From: ENVU Biodiversity and Land Use
Sent: 27 May 2025 12:58
To: Planning ContactCentre
Subject: 2025/90621 at location Westborough WMC, Brunswick Street, Westborough, Dewsbury, WF13 4ND

Please see ecological commentary below.

title SITE PLAN

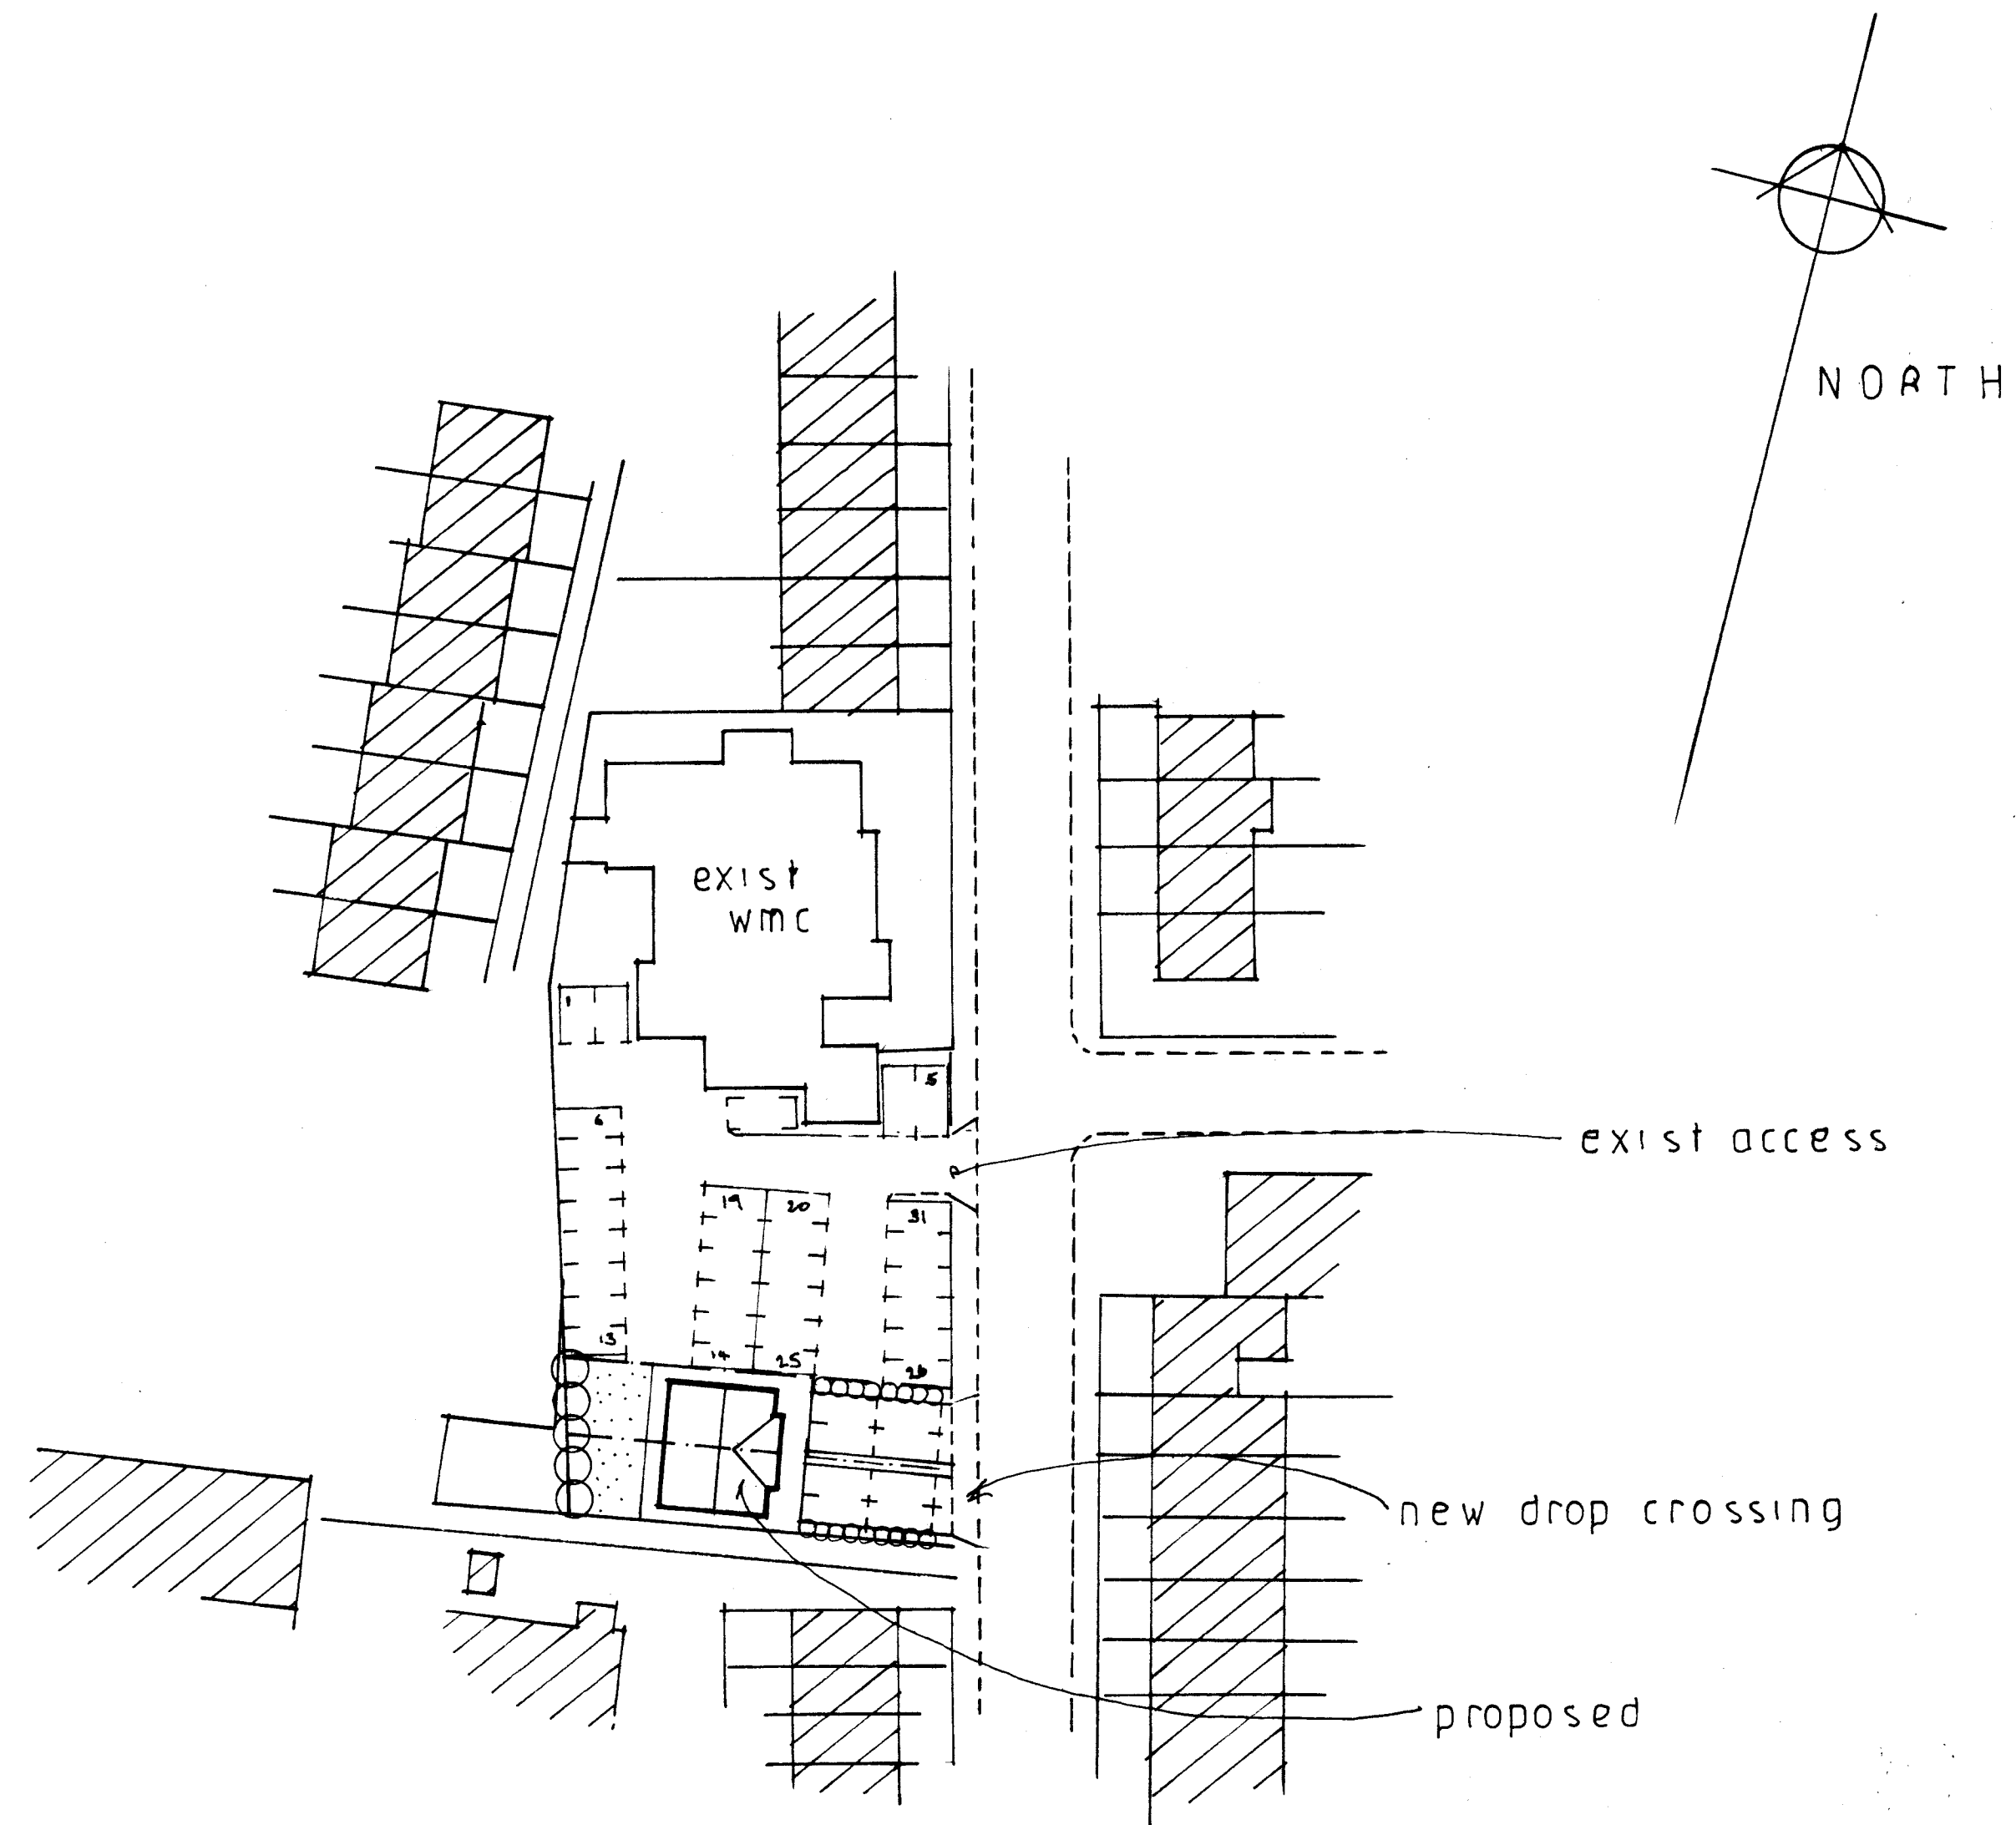
There appears to be a mature tree in the southwest corner of the site. A tree protection plan should be provided to ensure a little disturbance to it as possible.

A Hedgerow and Tree Protection Plan detailing measures for the protection of trees and hedgerows during the works will be submitted to and approved by the LPA prior to the commencement of works on site, including site clearance and delivery of materials.

Hedgerow and tree protection measures will include temporary fencing for the protection of hedgerows in accordance with BS 5837:2012 Trees in relation to design, demolition, and construction – Recommendations. Any alternative fencing type or position not in accordance with BS 5837:2012 will be agreed in writing by the LPA prior to the start of development.

The root protection fencing will define the works exclusion zone around hedgerows and trees. Activities liable to be harmful to hedgerows and trees are prohibited within this exclusion zone, unless agreed in writing with the LPA. The approved hedgerow and tree protection measures will remain in place until the completion of development or unless otherwise agreed in writing with the LPA.
